Application No: AW/272/21/HH
Site Address: 73 Marlborough Court Bognor Regis PO21 5QJ
Description of works: Single storey rear extension and conversion of garage to kitchen

Thank you for your internet representation made on 23rd September 2021 which has been recorded as an objection with the comments as follows:

Proposed Elevations

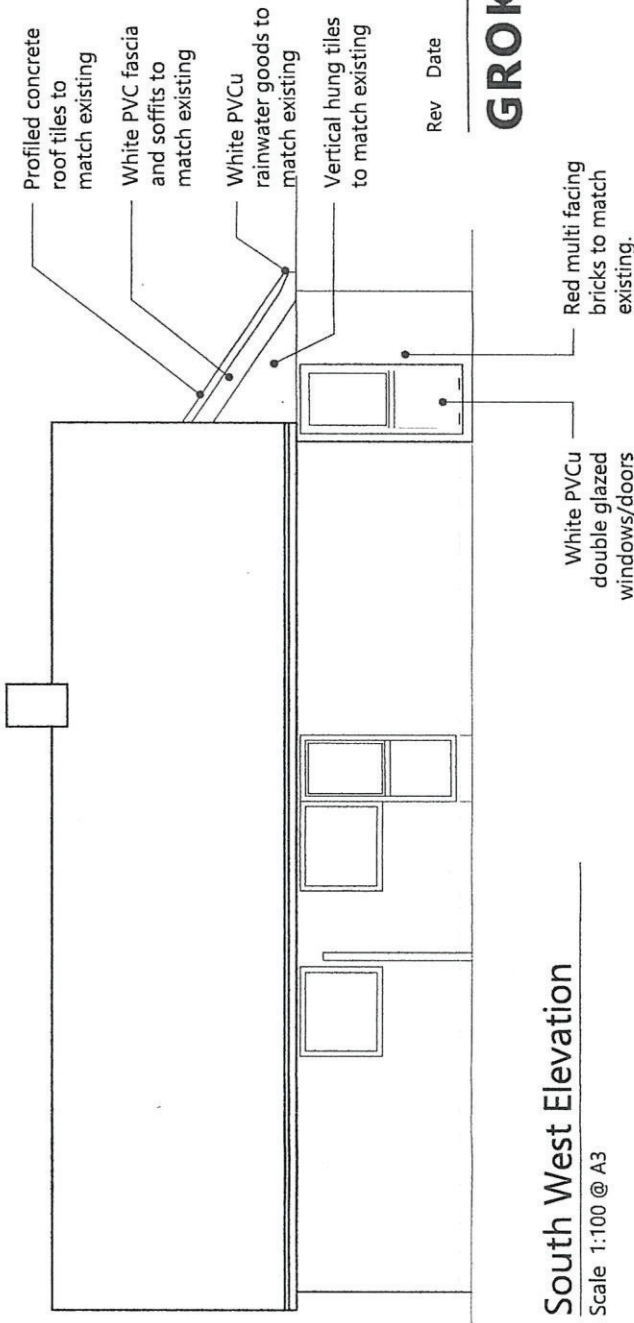
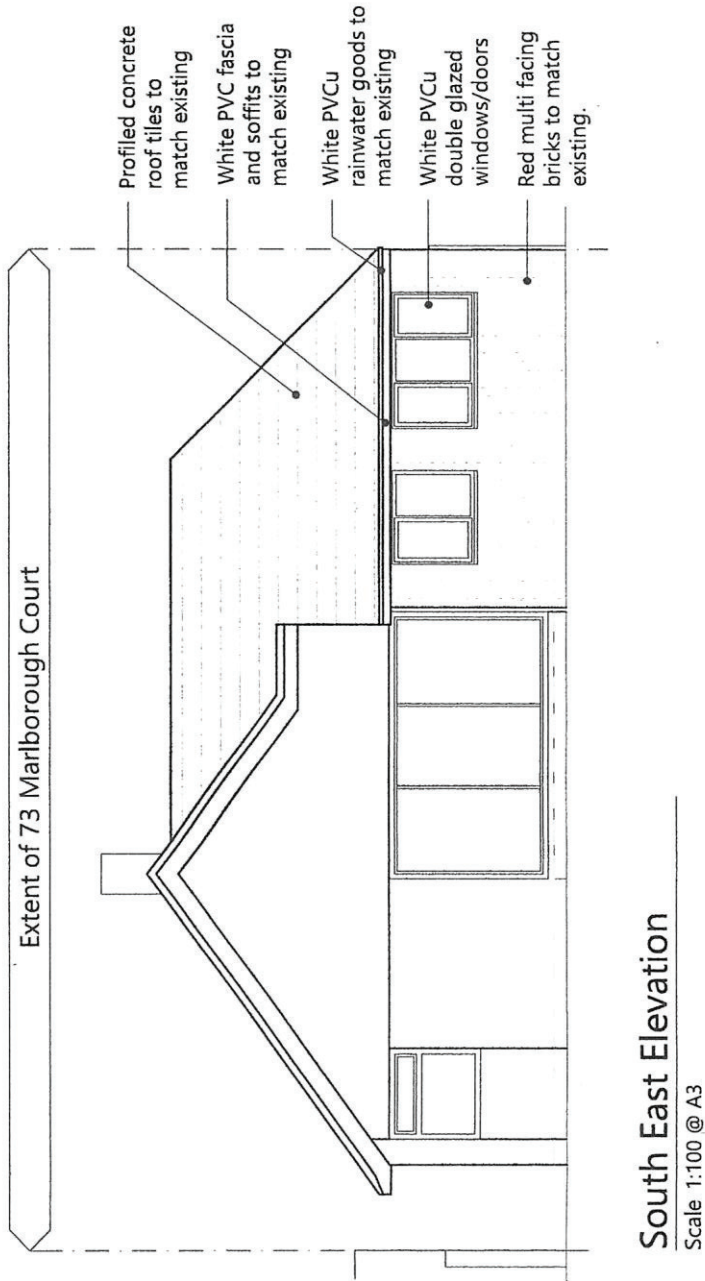
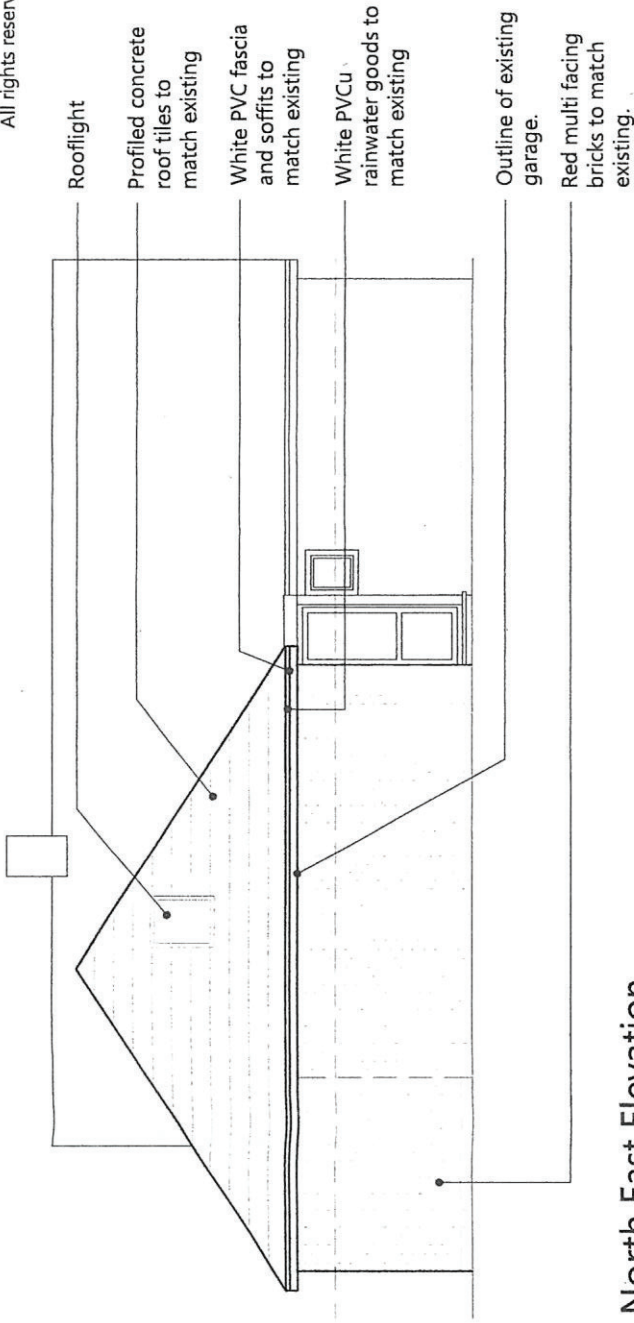
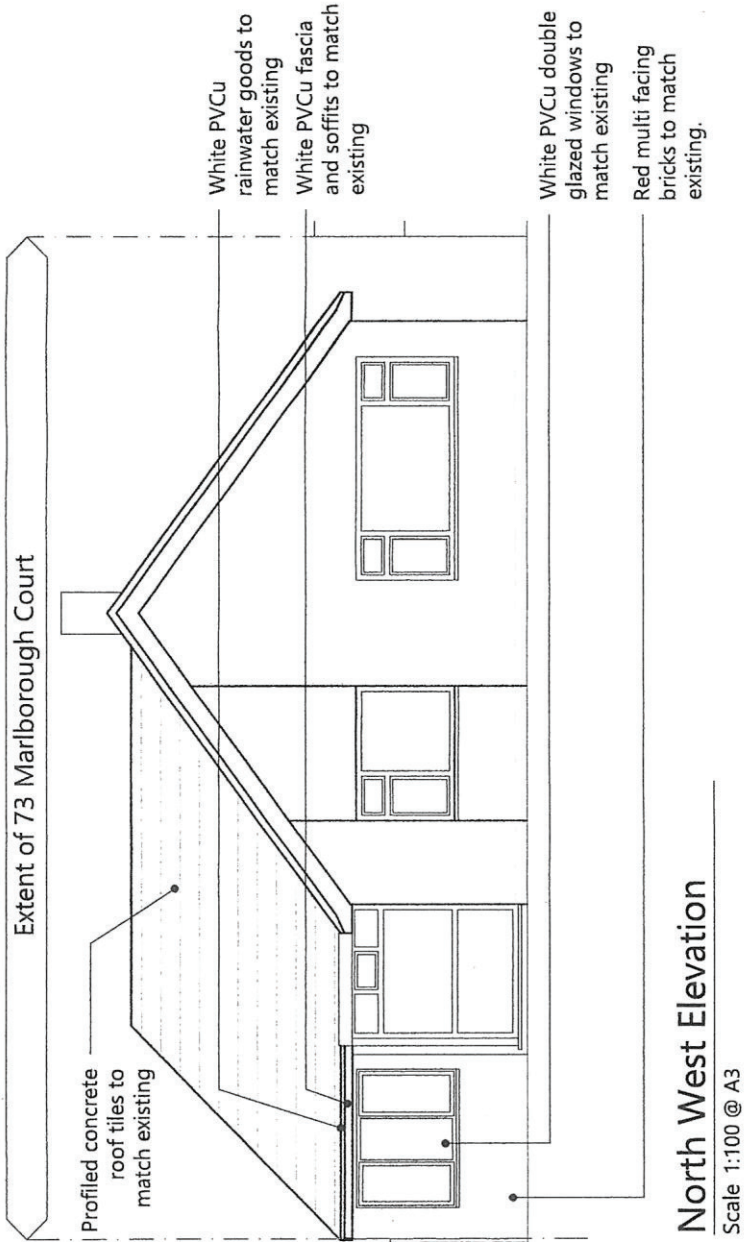
I HAVE CONCERNS ABOUT THE SIZE OF THE REAR ELEVATION WHICH IS ON THE BOUNDARY LINE. IT WILL BE VISUALLY VERY INTRUSIVE AS IT EXTENDS OVER 2.5 METERS FROM THE REAR OF THE PROPERTY AND APPROX 3METERS HIGH. ALSO THE APPLICANT HAS NOT EVEN ASKED ME ABOUT THE PROPOSED BUILDING WORKS WHICH WILL HAVE TO BE DONE ON MY PROPERTY AS THE EXTERNAL WALLS ARE ALL ON THE BOUNDARY LINE.
